**PROPOSED MULTI FUNCTION HALL SPACE AND ASSOCIATED
ACCOMMODATION
AYSCOUGH FEE HALL SCHOOL - SPALDING
PLANNING REF: H16/1339/01**

Following receipt of the approval notices for the above scheme, we now enclose for your review copies of our amended elevations indicating the following revisions, outlined in the approval conditions.

Amended elevations

Dwg. Nos. 01.015/18A; /19A; /20A & /38

Title
Photomontage of
Proposed School Hall

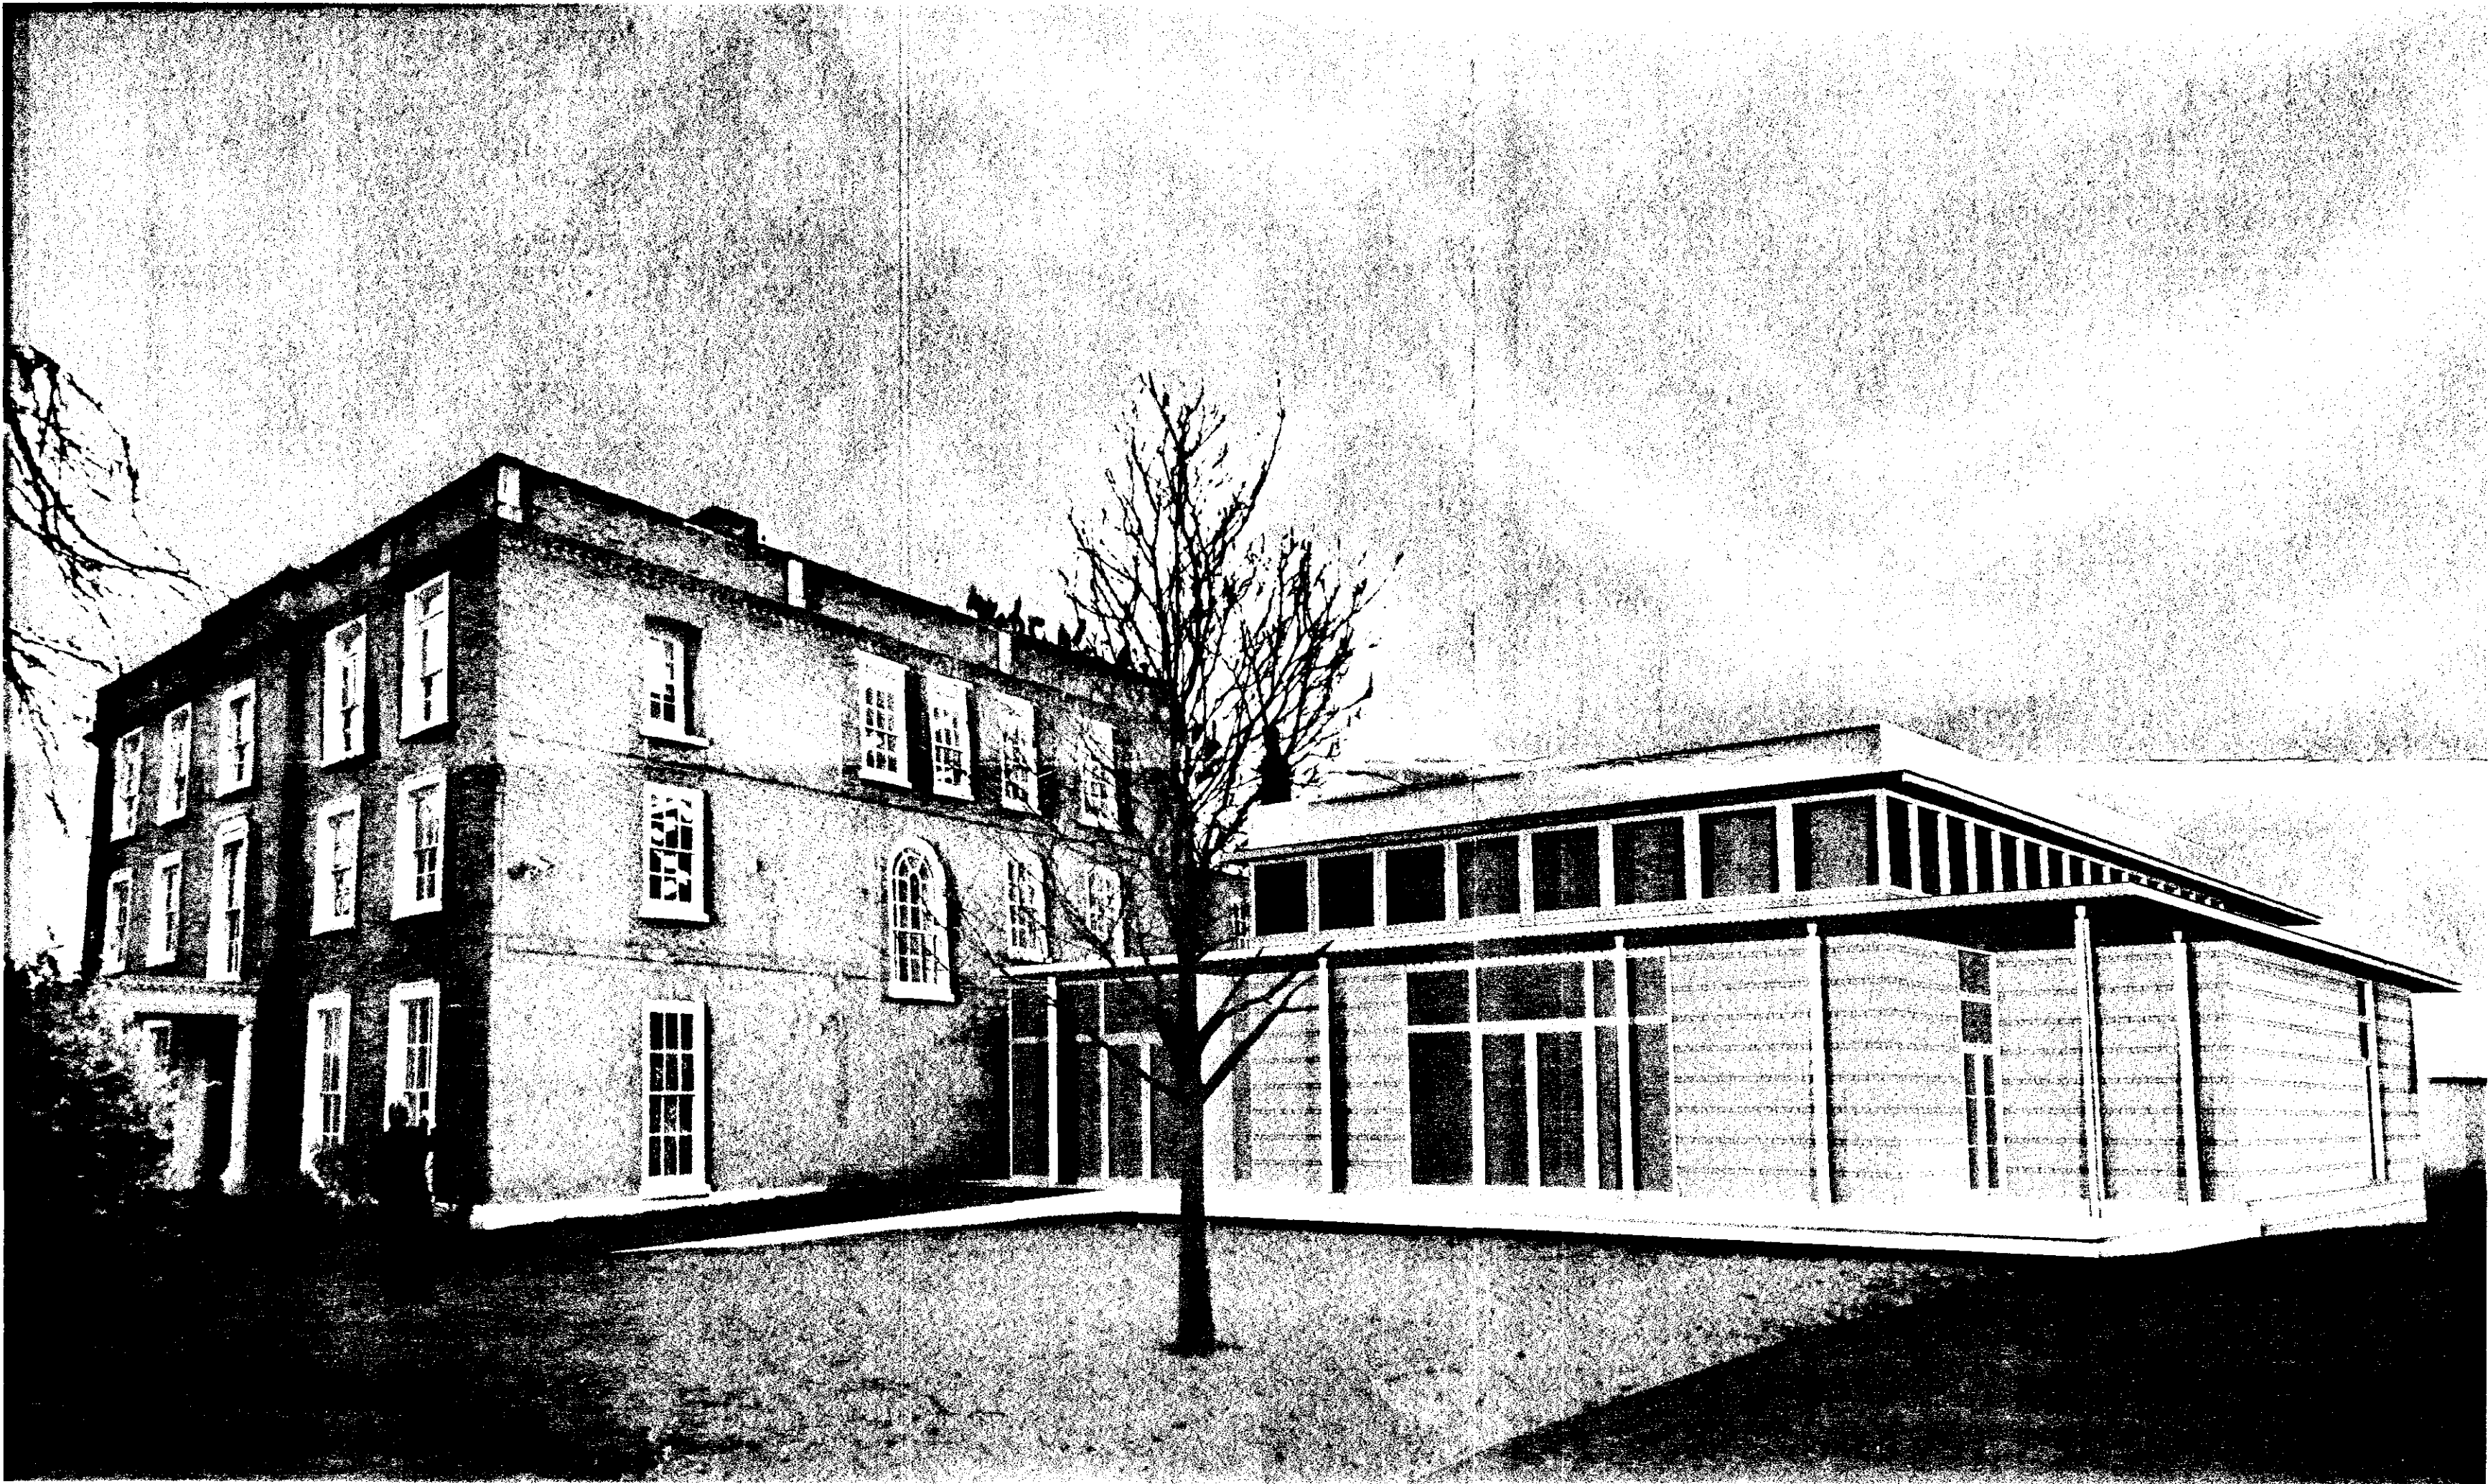
In addition to the amended drawings, we have also enclosed a rendered 3D image which may help visualise our proposals in context with Welland hall house.

TITLE
Proposed South East &
South West Elevations.
Alternative Roofline

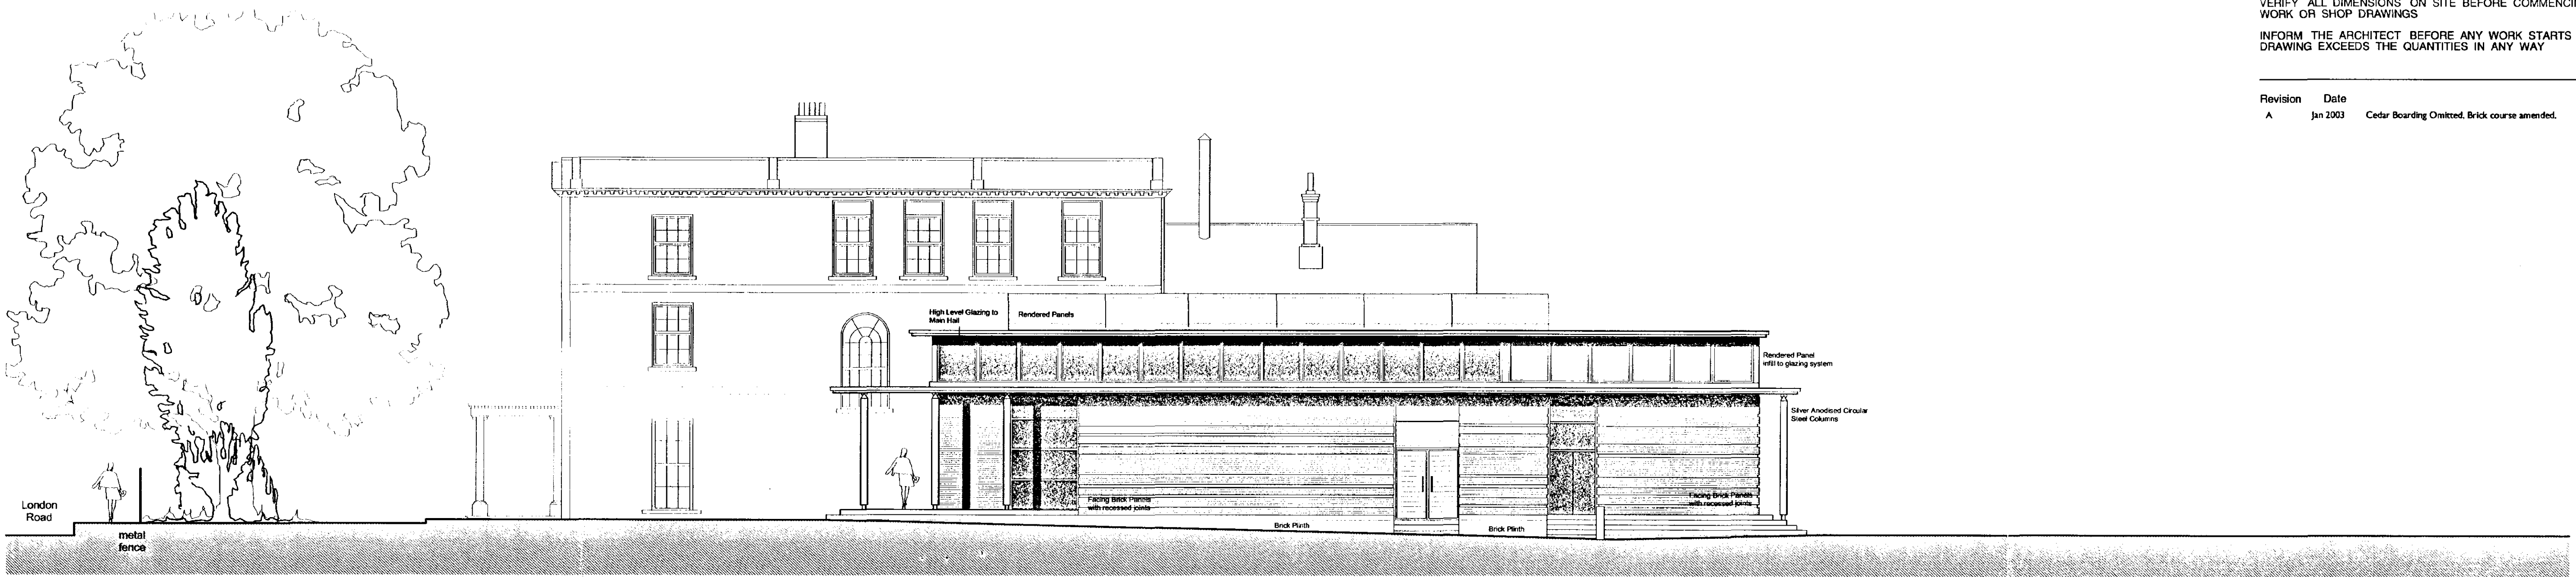
- i. The high level cedar boarding, previously noted on the elevations has been omitted, in favour of a insulated rendered panel. We propose to use the Rockwook Rockshield system, which can be impregnated with various colour pigments (see enclosed literature). Boarded panels have also been omitted as an infill to the glazing system.
- ii. As outline in our correspondence dated 9 January 2003, we also propose to omit the contrasting string course detailed previously in our drawing 01.015.20 (part elevation). This has been amended to a matching red lacy brick (IB stock cheddar red) recessed 15mm, in order to make visual reference to the existing banding detail, to the North East elevation of Welland Hall house.
